## On behalf of Lingwood and Burlingham Parish Council.

Deadline 5. 19<sup>th</sup> October, 2021

Re: Highway England's documents\_REP 023 and REP 024.  
TR010040. Vol 6,  
6.1 : Environmental Statement  
Chapter 12 – Population and Human Health. Sept 2021

Figure 2-7: Route of Burlingham FP3

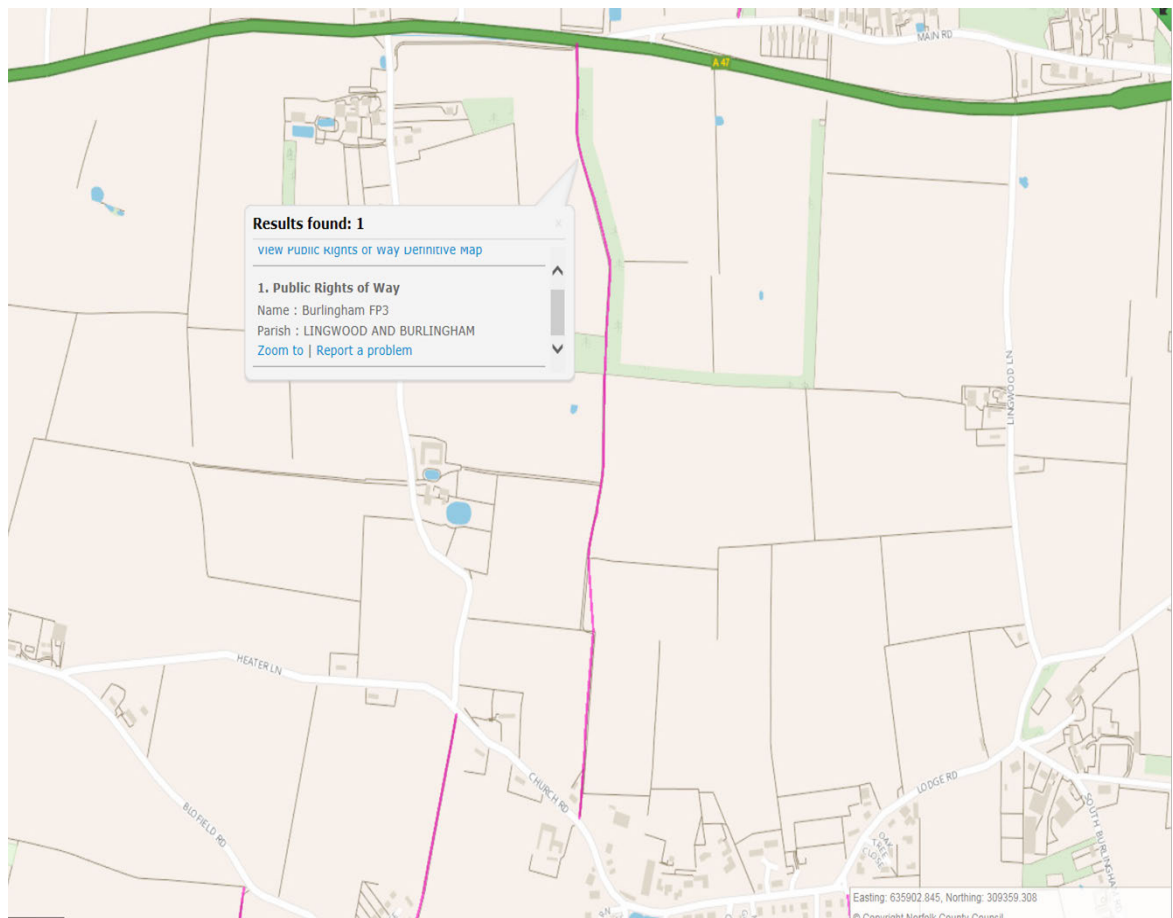
5) "12.9.53:..... In the future, users making a trip between Lingwood and North Burlingham via Burlingham FP3 would be required to divert to the proposed WCH route running west to east parallel to the proposed agricultural access track to connect to the proposed Blofield Overbridge and then continue their journey via the overbridge and the proposed new combined footway/cycleway to be provided on the northern side of the former A47, which would be de-trunked. Alternatively, users could follow the proposed WCH route to the east as far as the B1140 junction and access North Burlingham via the new footway/cycle track links. Although both the Blofield Overbridge and the B1140 junction would facilitate the safe crossing of the new A47 alignment for users, the resulting increases in journey length would be in excess of 500m. The sensitivity of Burlingham FP3 has been classified as medium due to observed usage being very low and the trips being for recreational purposes only. The magnitude of the impact is major as severing the route would result in a permanent increase in journey length in excess of 500m for users. Effects are therefore assessed as permanent Moderate adverse given the very low usage of this unsurfaced, recreational route which does not provide direct access to community assets."

The increase in journey length over the proposed B1140 overbridge from the point where FP3 meets the A47 is approximately 2.2 miles, or 4.4 miles for a round trip. This detour will take the walker along a path adjacent to a busy dual carriageway, then across an overbridge used by up to 700 heavy goods vehicles per day in peak season on their way to Cantley Sugar Factory (each of which has to make a return journey over the overbridge), then back along the other side of the A47. The return journey will be the same in reverse. (Re. the HGVs, please see confirmation from British sugar at REP2-016.) Highways England seems to assume this 4.4 mile detour will be acceptable for

As explained in previous submissions, the '*very low usage*' recorded on FP3 is because walkers can no longer cross the A47 safely and, therefore, most choose to drive to North Burlingham woods, which has a high usage.

It is incorrect to say FP3 '*does not provide direct access to community assets*'. It is the shortest route from North Burlingham to the school, station, bus stops, village hall, etc. which are well within walking distance if parishioners were able to cross the A47 safely. An underpass would provide access to FP3 and to Lingwood Road, which is only about 250m from the point where FP3 meets the A47 and provides an alternative walkable route into Lingwood.
